From: [David O'Connell](#)
To: [Michelle Niles](#)
Subject: RE: Notice of Modification Request - Casuarina Town Centre Project Approval (MP 06_0258 MOD 12)
Date: Wednesday, 20 February 2019 4:12:37 PM
Attachments: [image001.png](#)
[image002.png](#)
[image003.jpg](#)
[image004.jpg](#)
[image005.png](#)
[image006.jpg](#)
[image007.jpg](#)
[image008.png](#)
[image009.jpg](#)
[Selection from Working copy - CC18_0924 - Civil Plans - Casuarina Way Ca....pdf](#)

Subject: Notice of Modification Request - Casuarina Town Centre Project Approval (MP 06_0258 MOD 12)

The proposal seeks approval to subdivide SP 94481 into two separate allotments, to correct an error in the Survey undertaken during works associated with MOD 6 which incorrectly amalgamated a car parking lot and medium density housing lot.

Figure 3 | Alternative Sewer Connection Locations

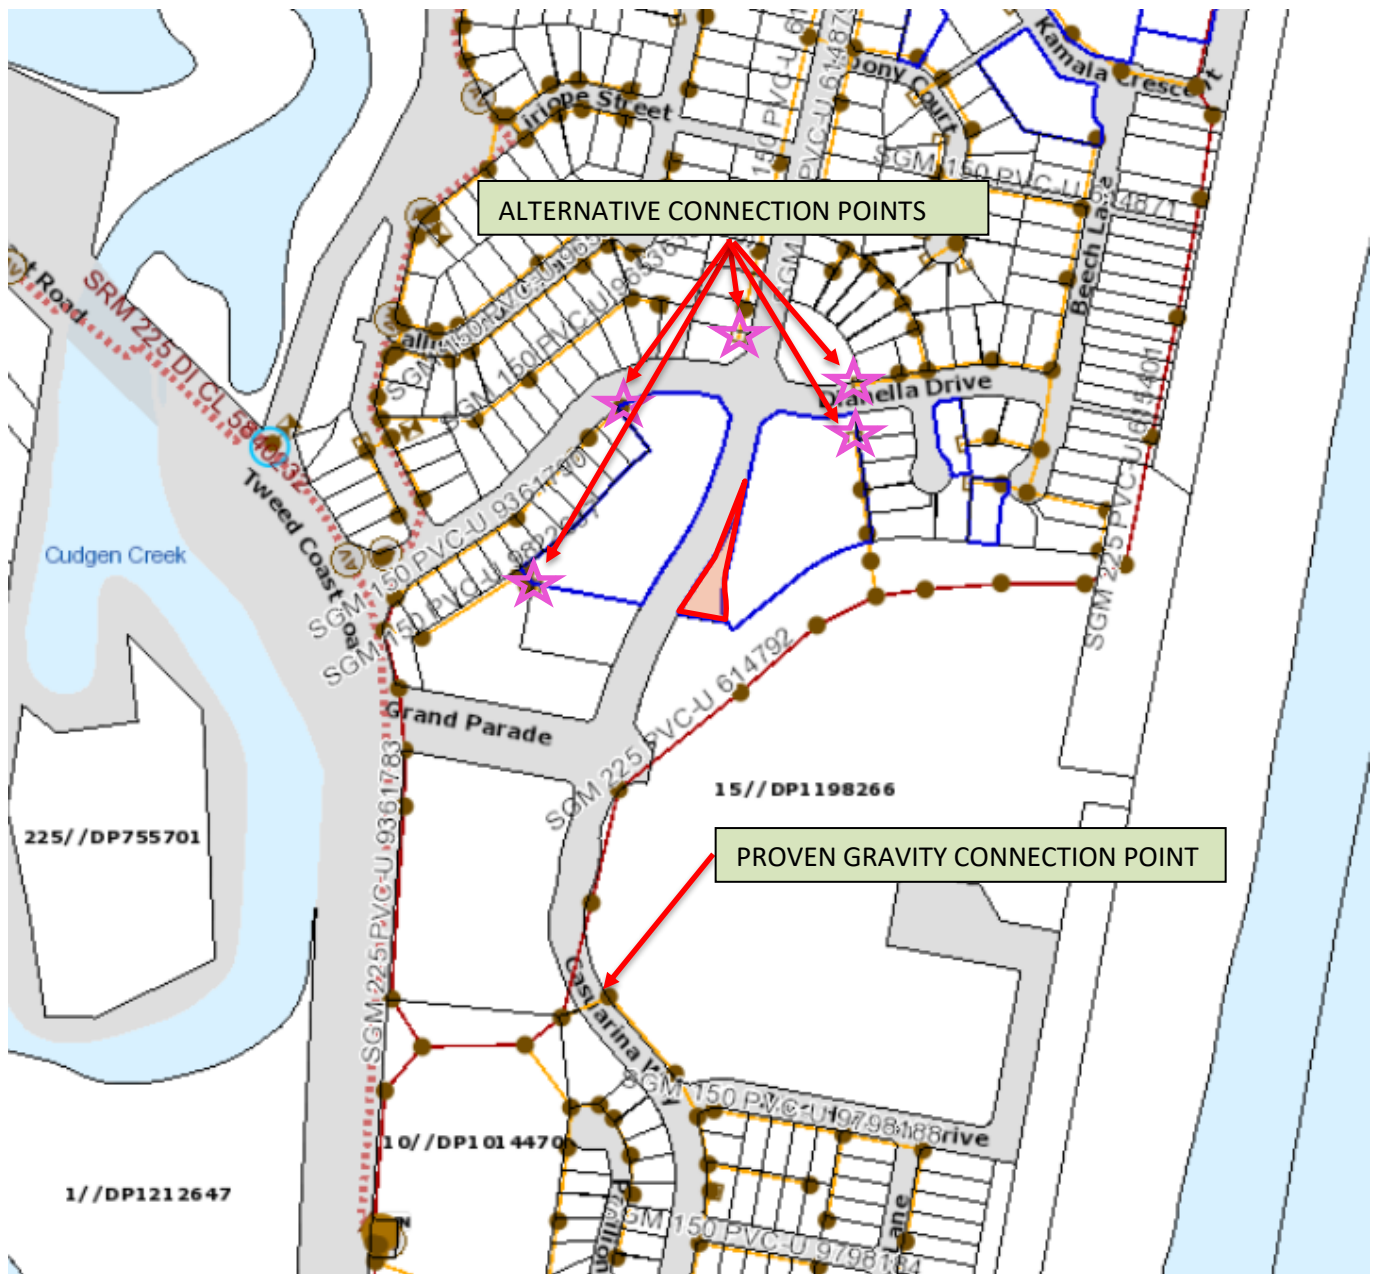
2) The application does not demonstrate how the car parking lot can be adequately serviced by sewer....demonstrate connection point and gradients.

b) Sewer - Council's piped effluent disposal infrastructure is available within the area, however it is not readily accessible for the car parking Lot 1 as the sewer is located some distance away in the form of a 225mm Sewer Trunk Main. Currently there is a previous modification over this site which seeks to relocate this trunk main.

Given the possibility of dwelling construction it is recommended that the developer demonstrate how the site will be connected with sewer to the proposed car parking parcel being Lot 1.

| DRAWING TITLE:<br>SERVICES CONNECTIONS |                      |                         |                      |           |

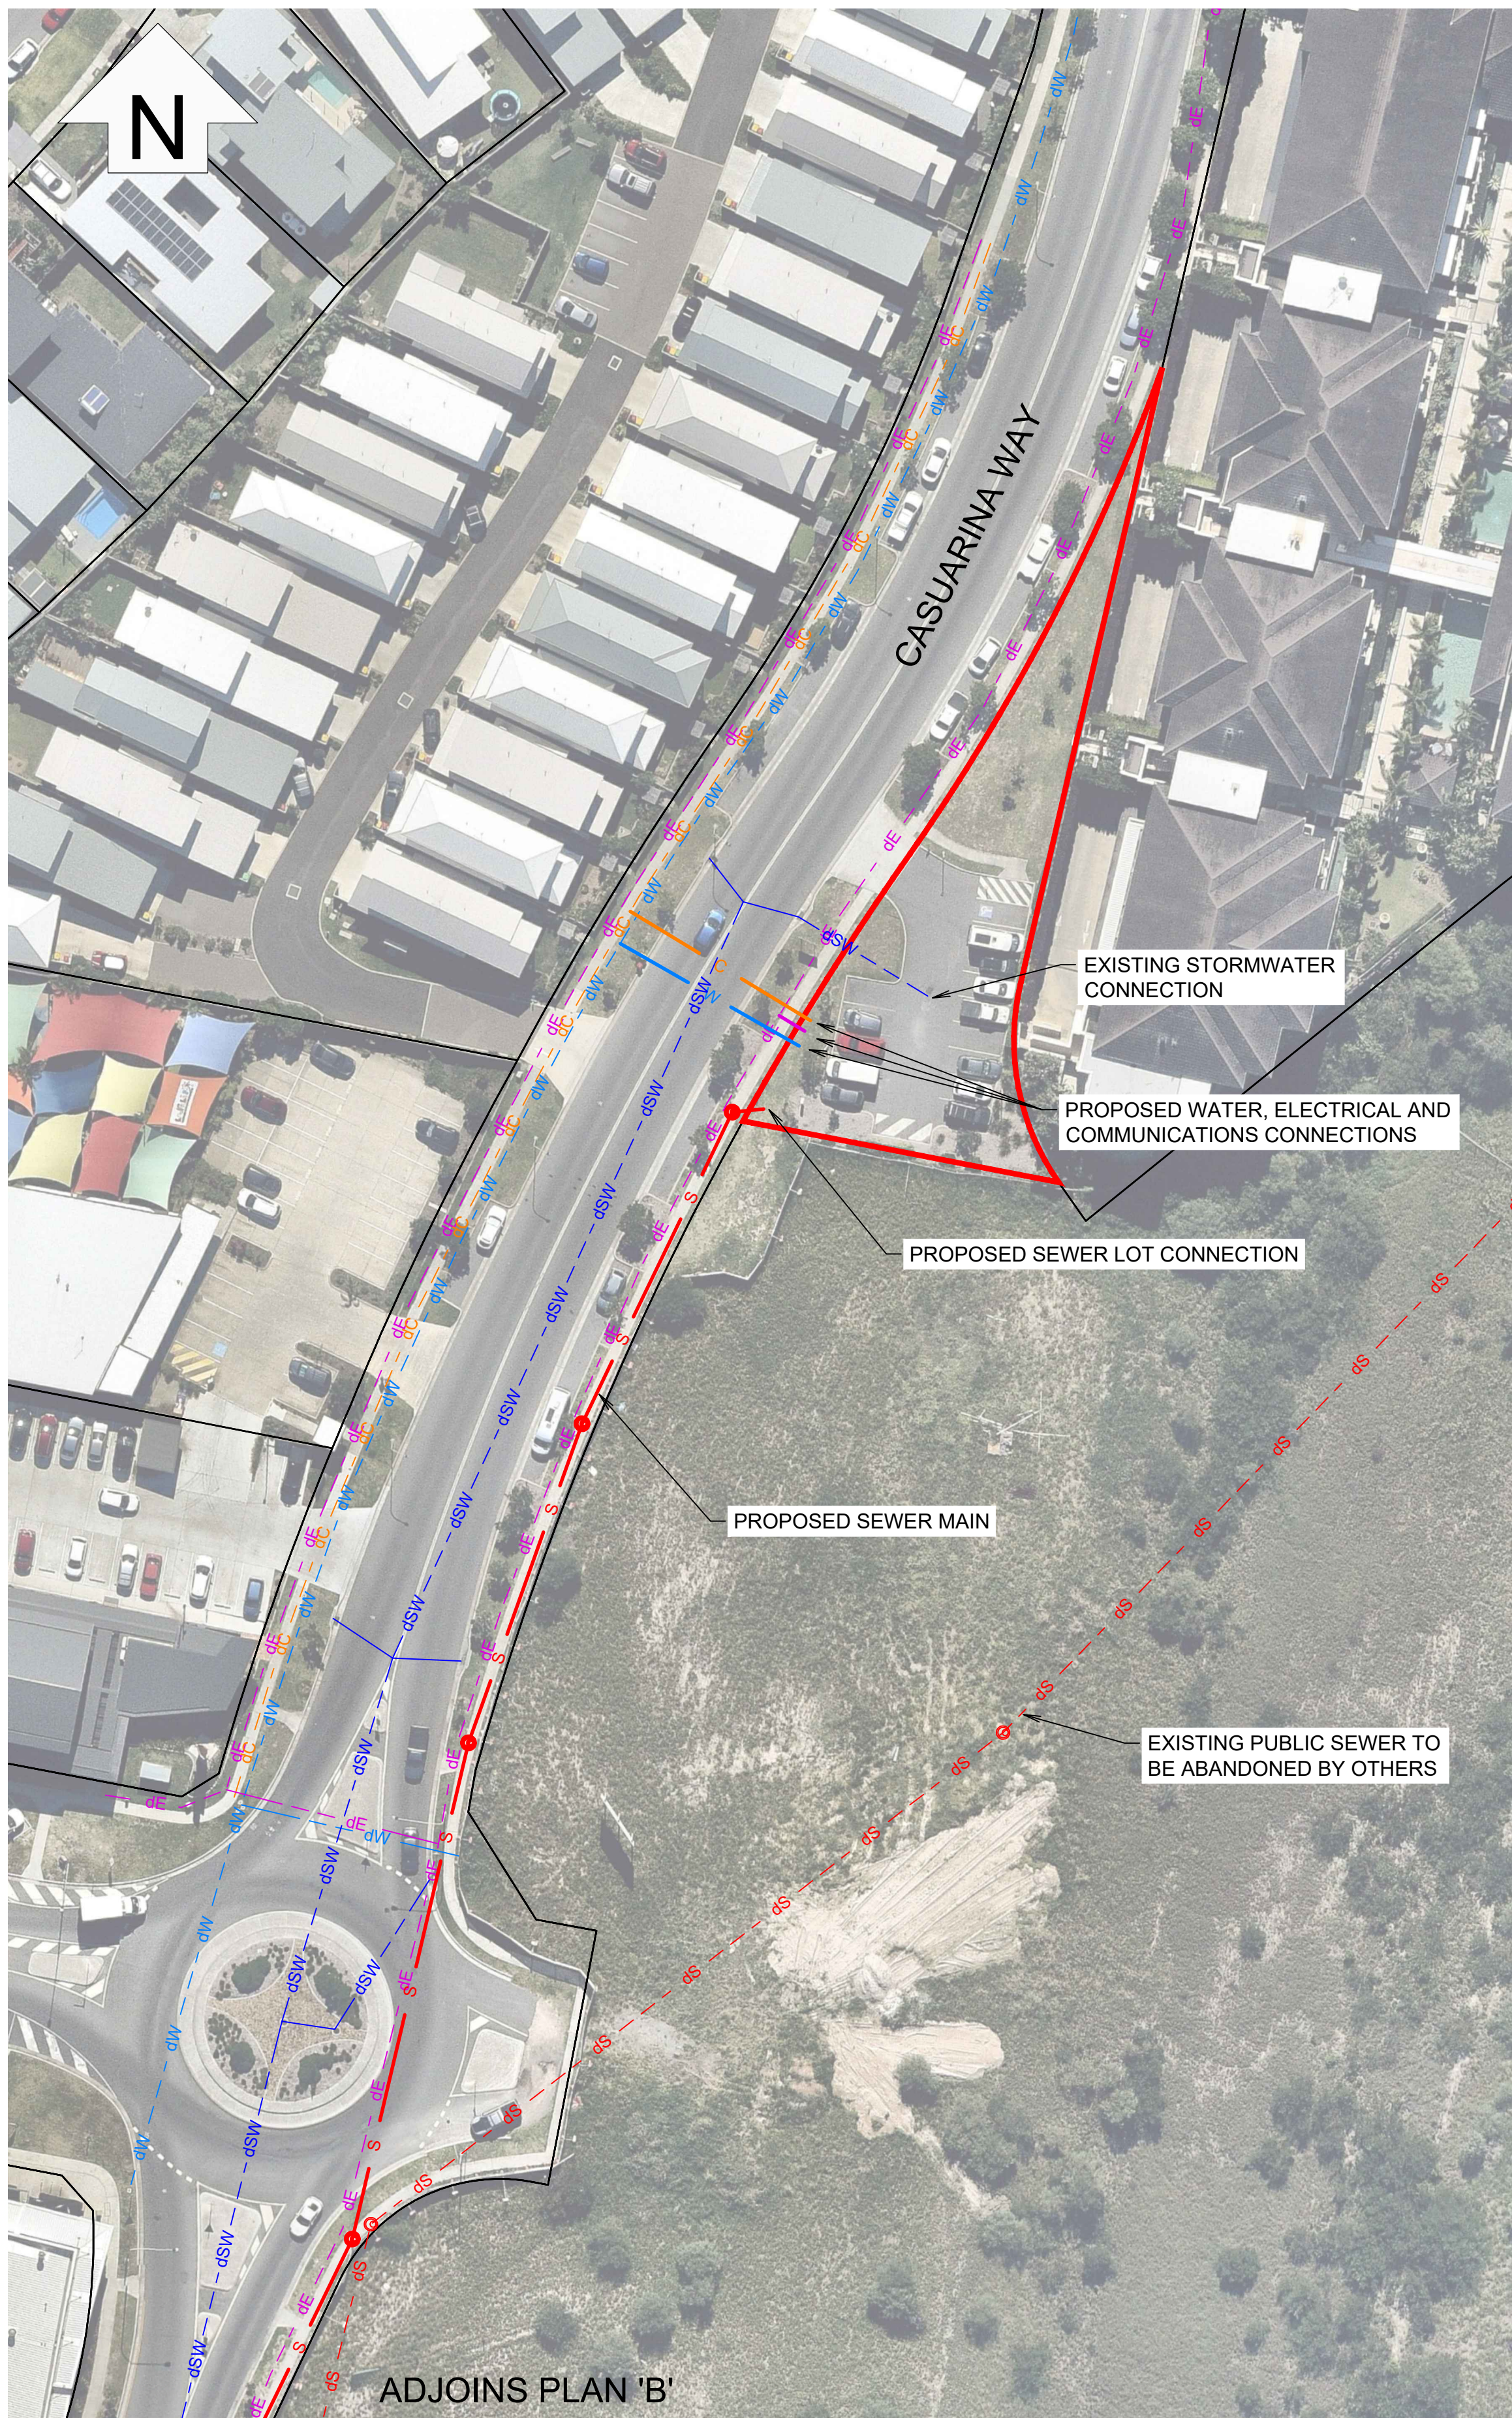
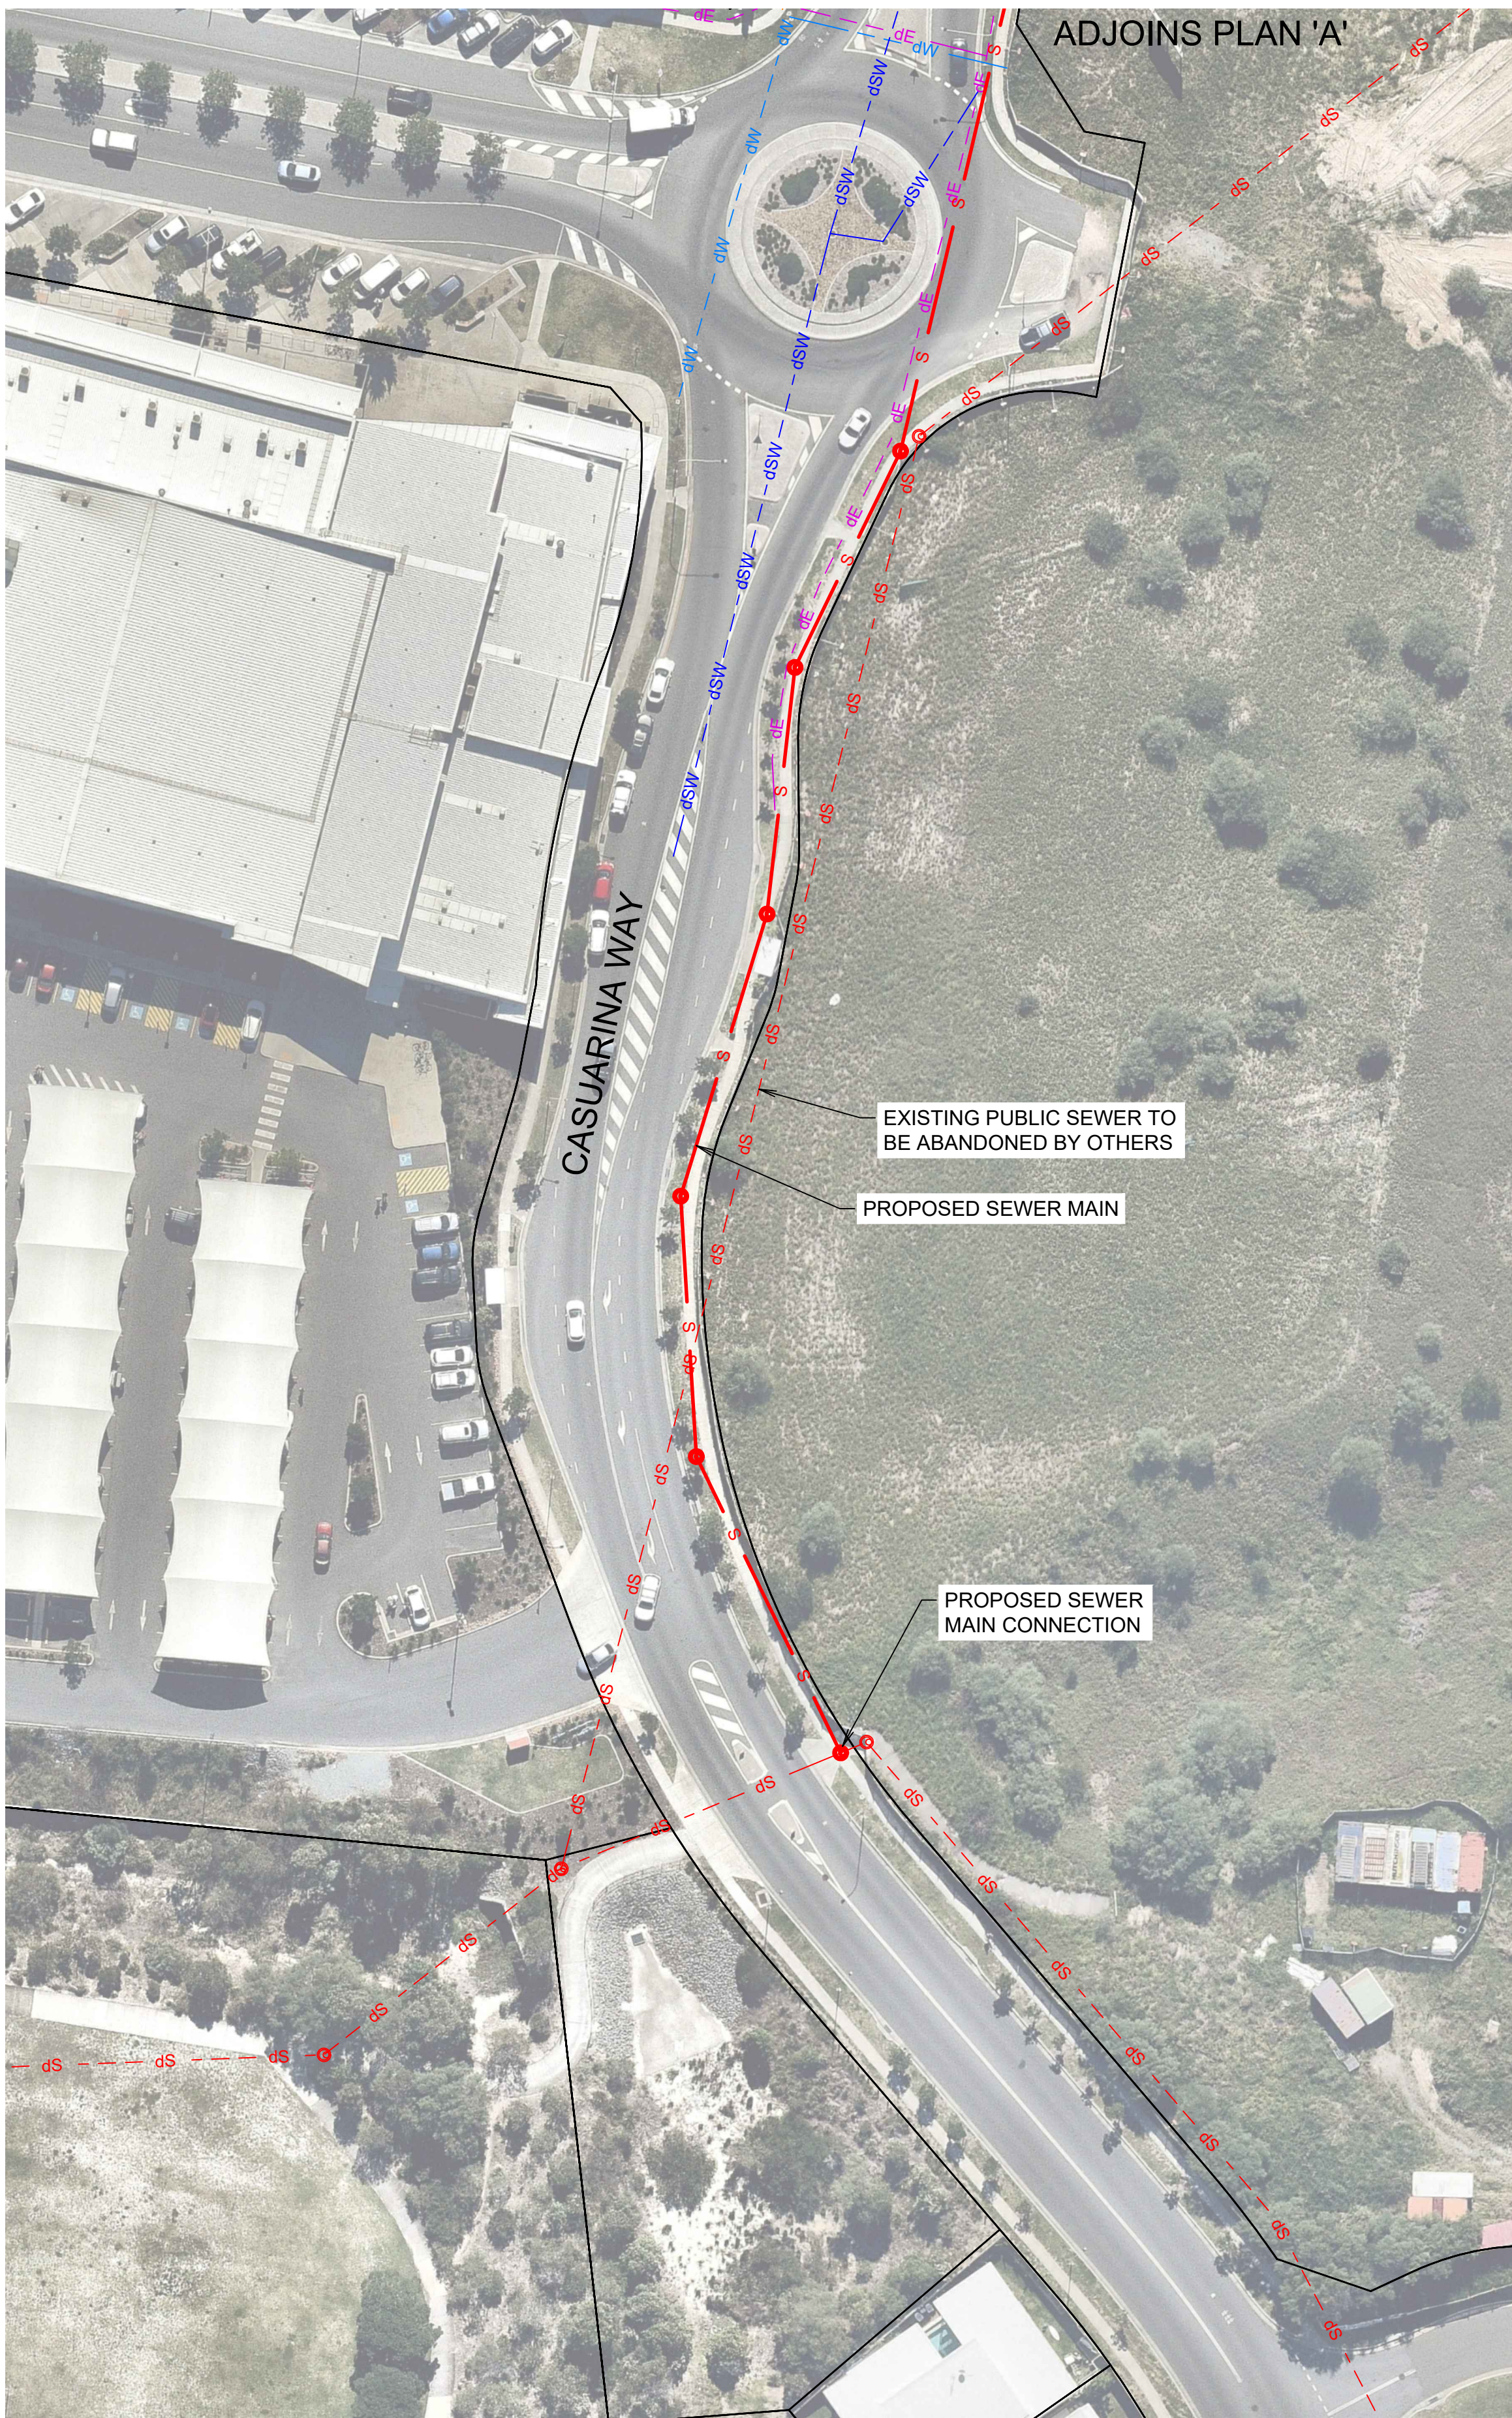
'It seems like they are proposing to connect into a trunk sewer line that is proposed to be removed / abandoned (see attached plan).

It seems the proposed sewer connection is inadequate.

Beyond this, detailed review of the submitted information has not been undertaken at this time, however I do note that sewer gradient levels are estimated which again does not provide Council with the requisite information to even assess the proposal.

The applicant has updated the information and recommended that the lot connect to the sewer proposed to the south of the lot, however has made no effort to confirm how the works would be undertaken or how owners consent for easements across private property would be obtained.
